From: clerk@sabdenparish.org.uk
Sent: 03 February 2021 22:58
To: Planning
Cc: Rebecca Bowers; Cllr R Newmark
Subject: Planning application 3/2021/0032

Planning Application 3/2021/0032 Replacement of unauthorised existing flat roof with a new pitched roof over a ground floor south facing rear outrigger. At 2 Pendle St West Sabden

Drawing Title
Proposed Sections and Elevations
Project
2 Pendle Street West, Sabden
Client
Jigsaw Homes Group
Scales @ A1
1:50
First Issue Date
08/04/2020
RIBA Stage - Drawing Status
[3] - Planning
Drawn
BB
Check
BY

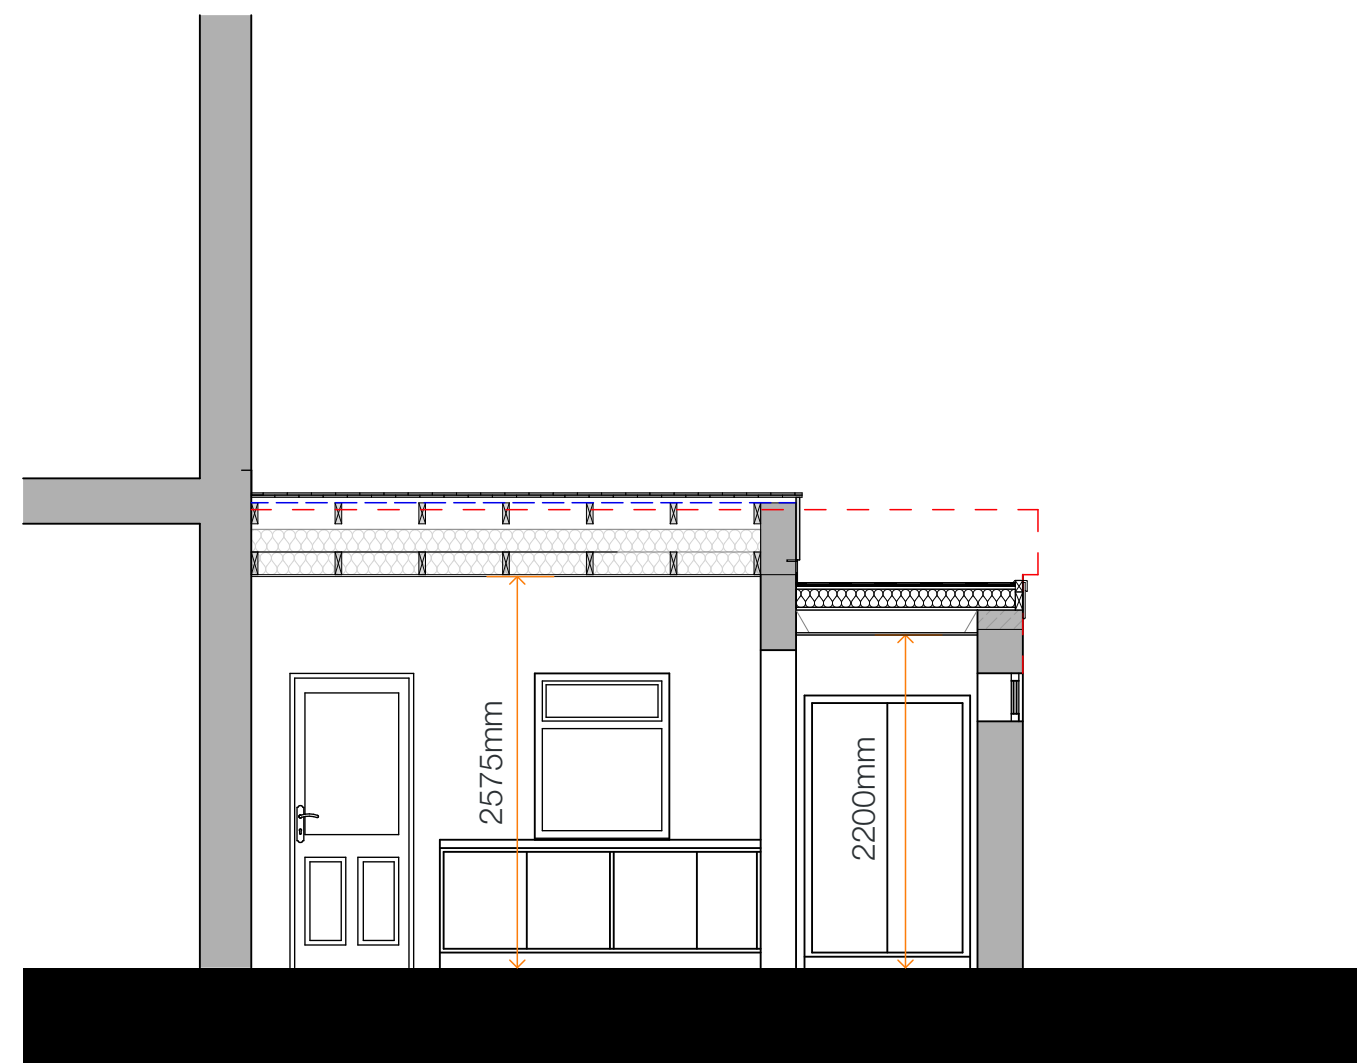
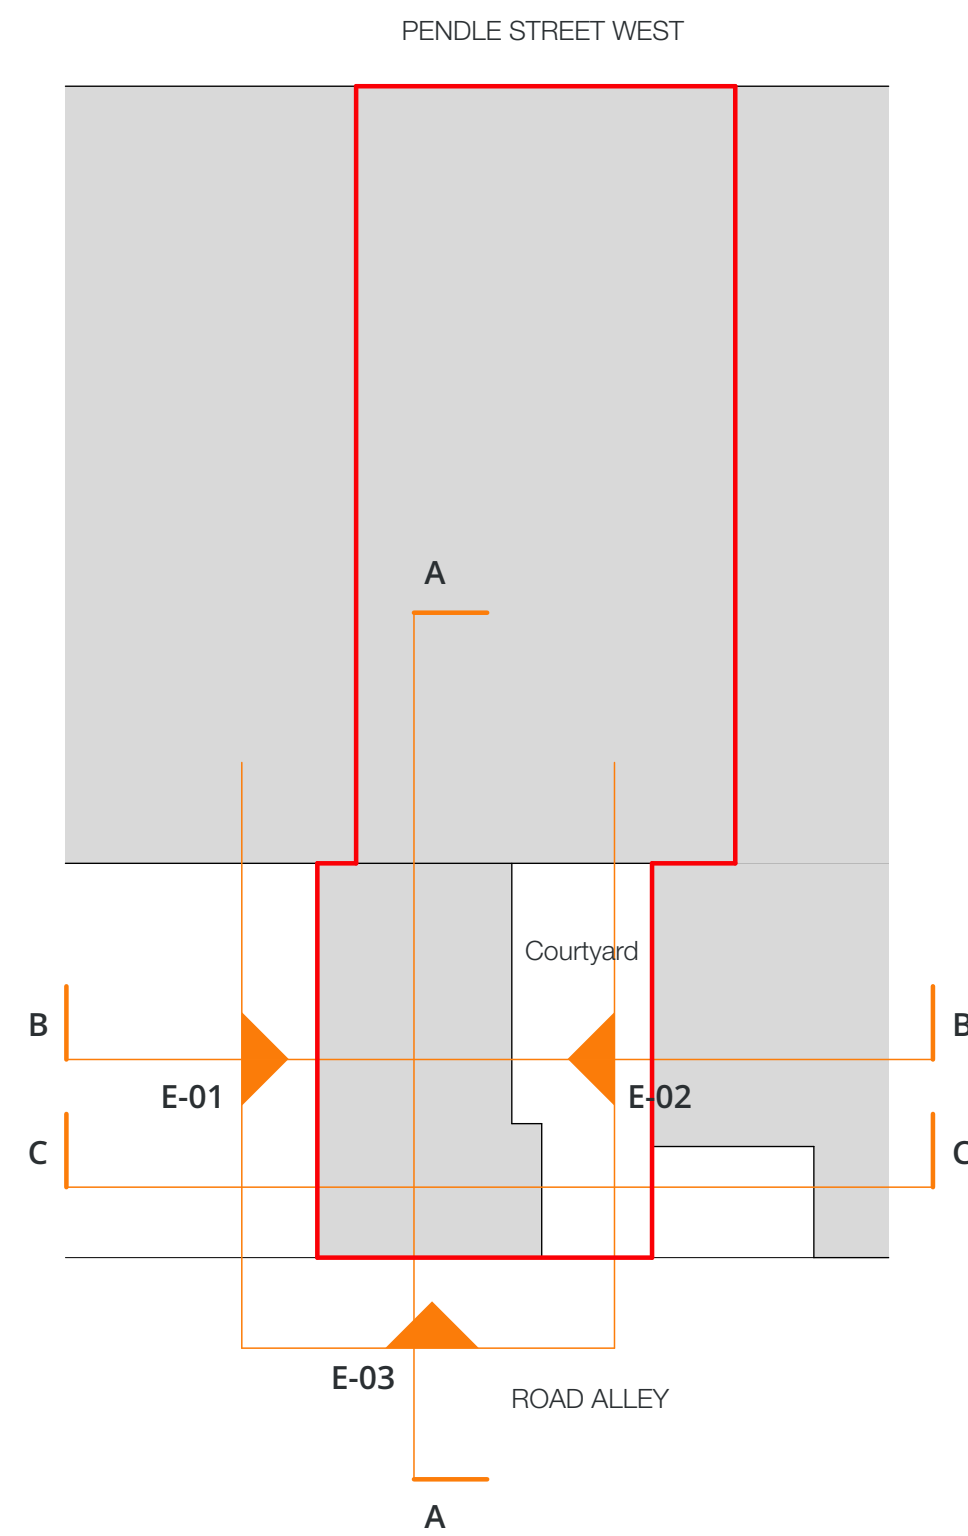
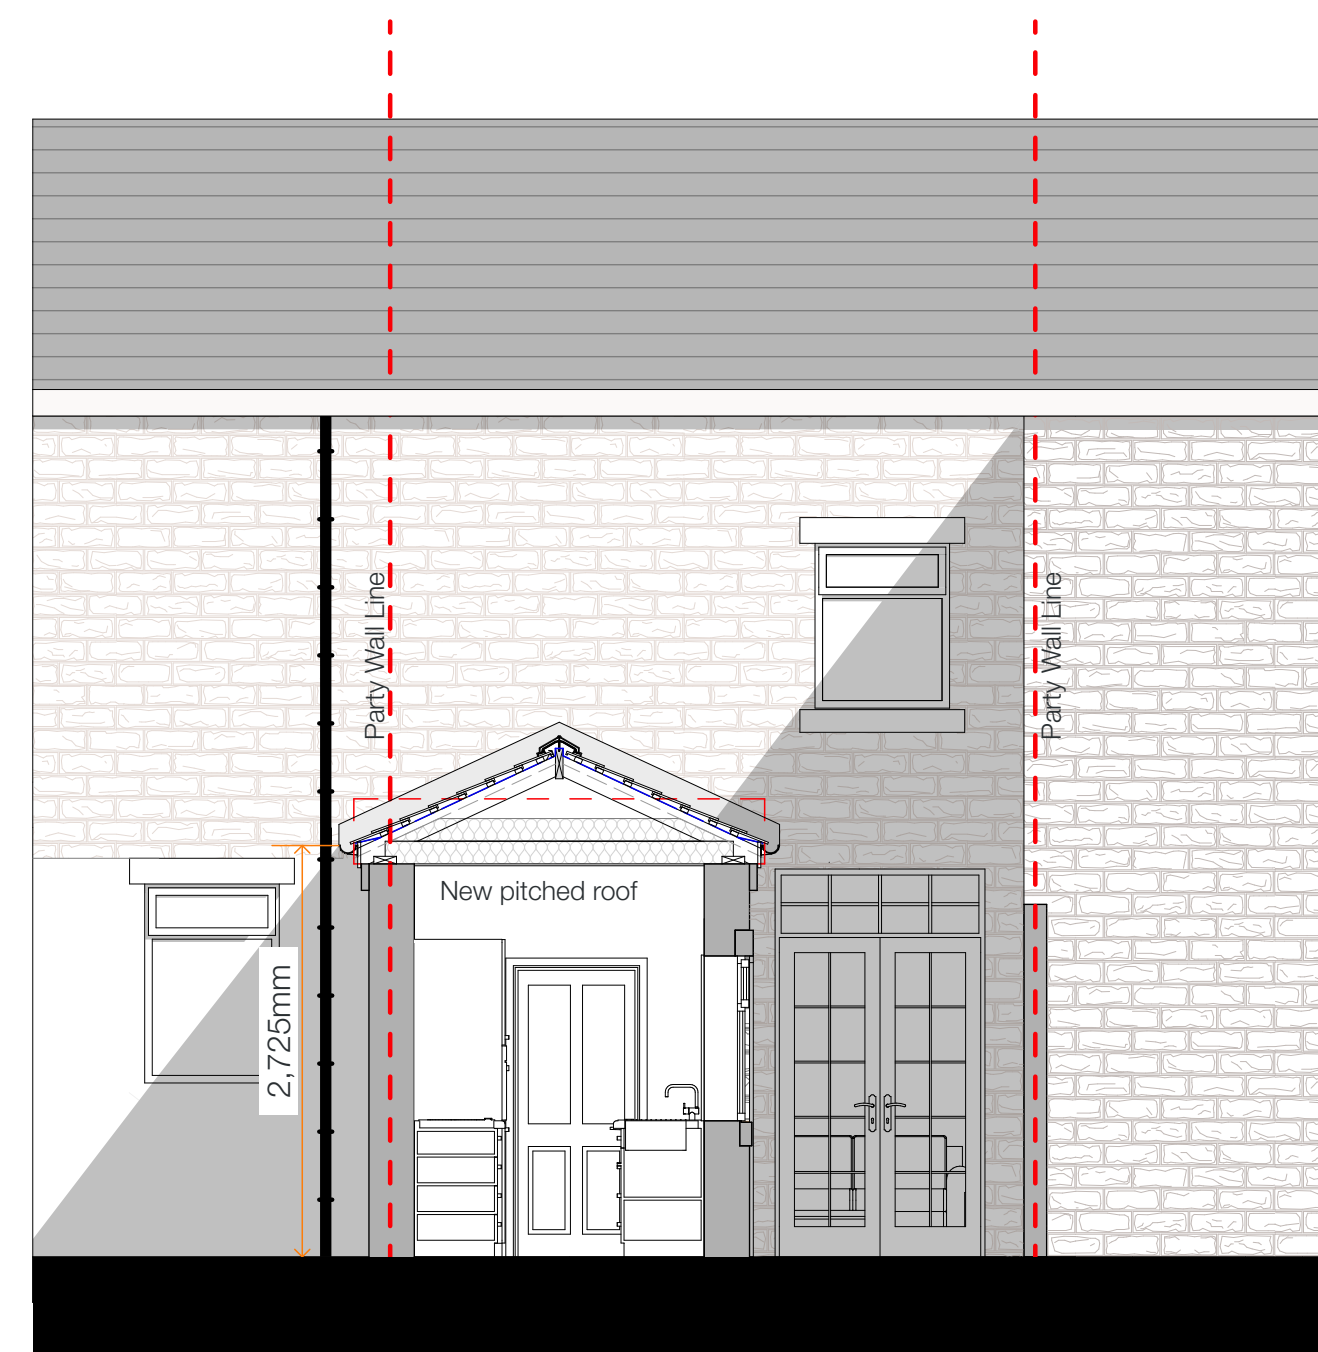
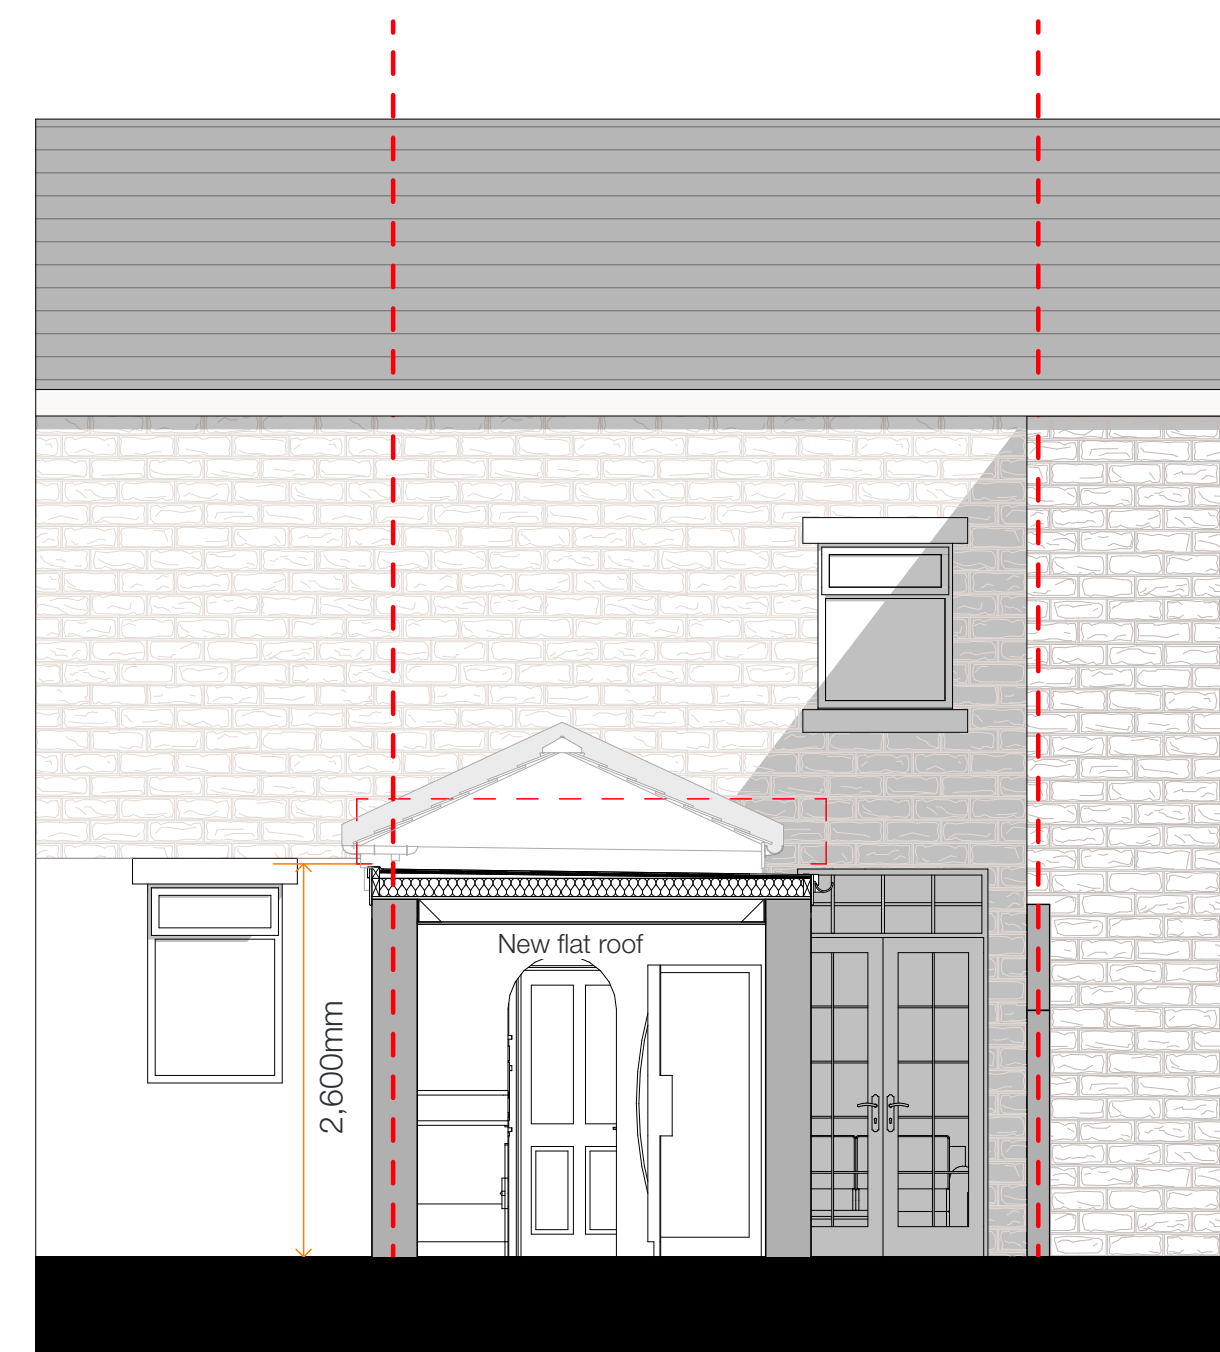
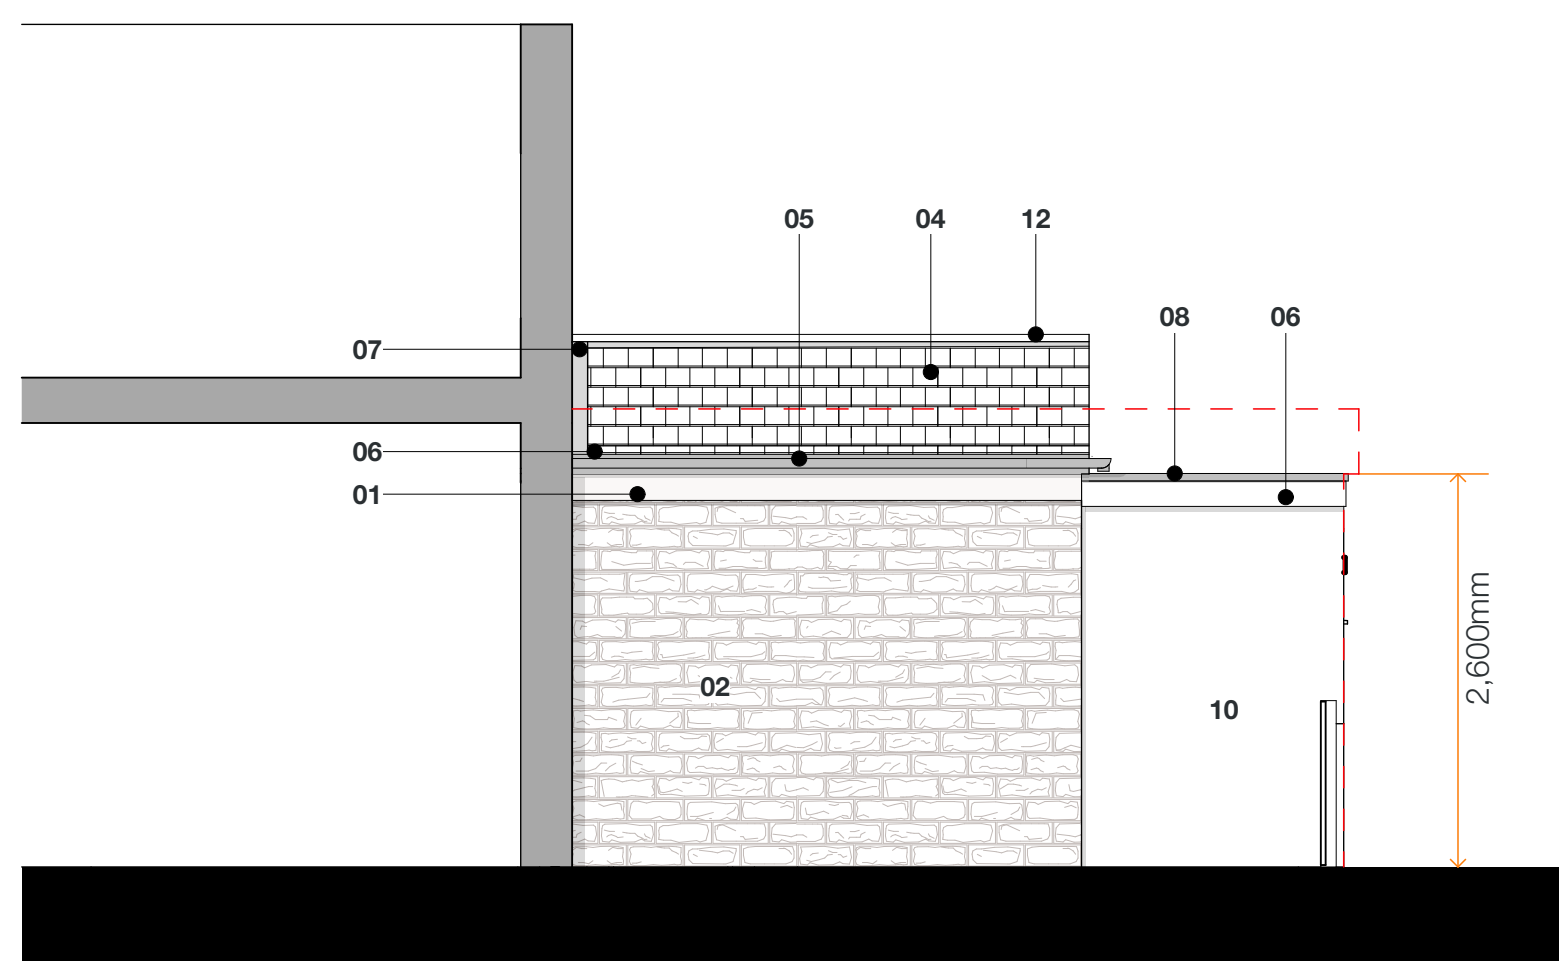
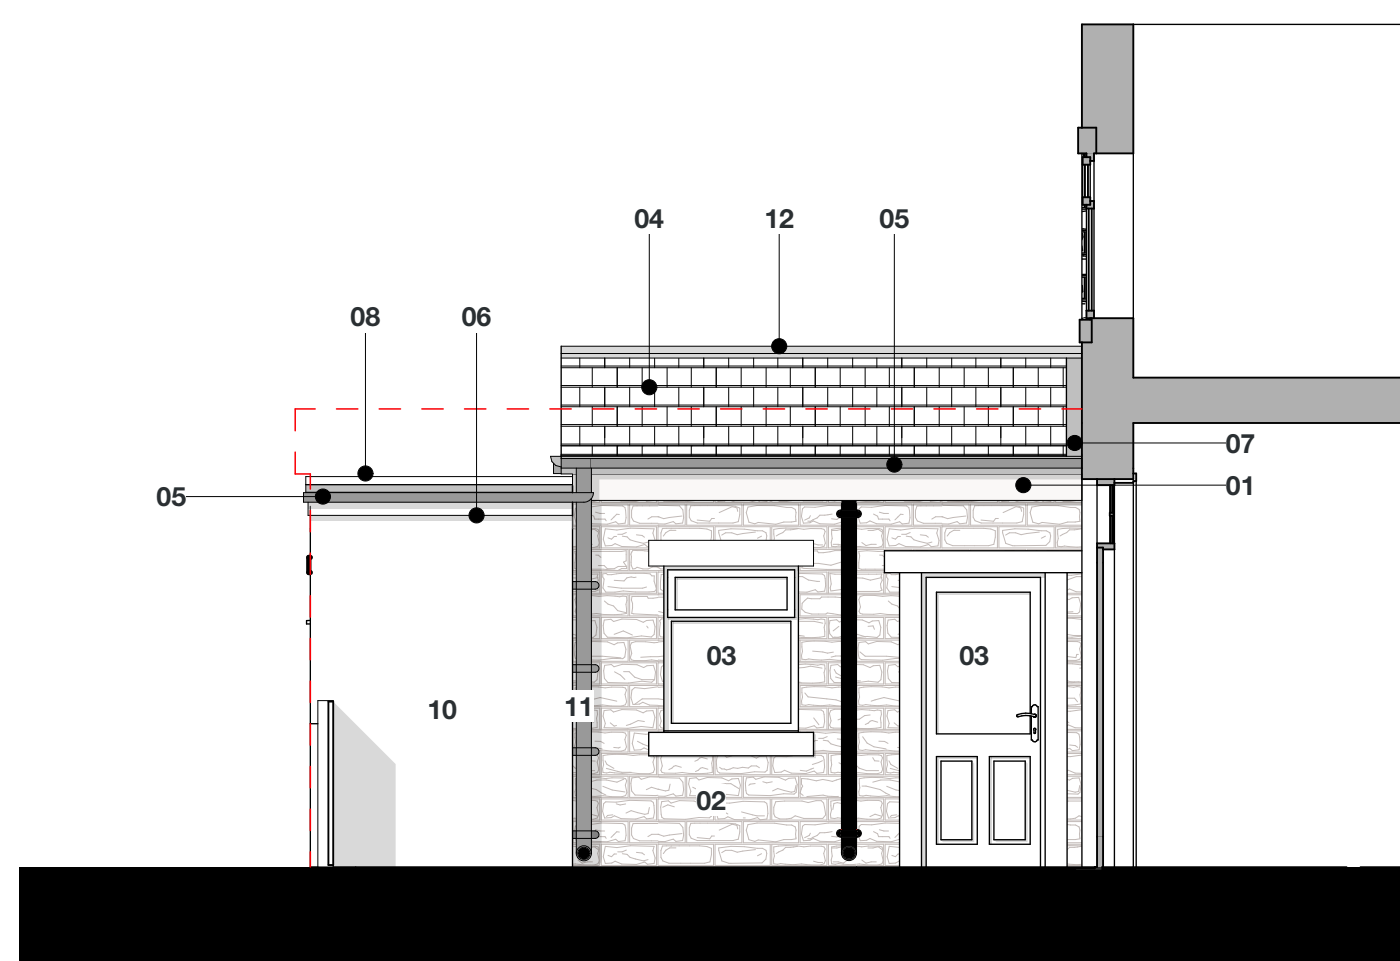
The plans show the fascia boards overhanging the party wall into the neighbouring property

The drainage pipes also extend into the neighbouring property.
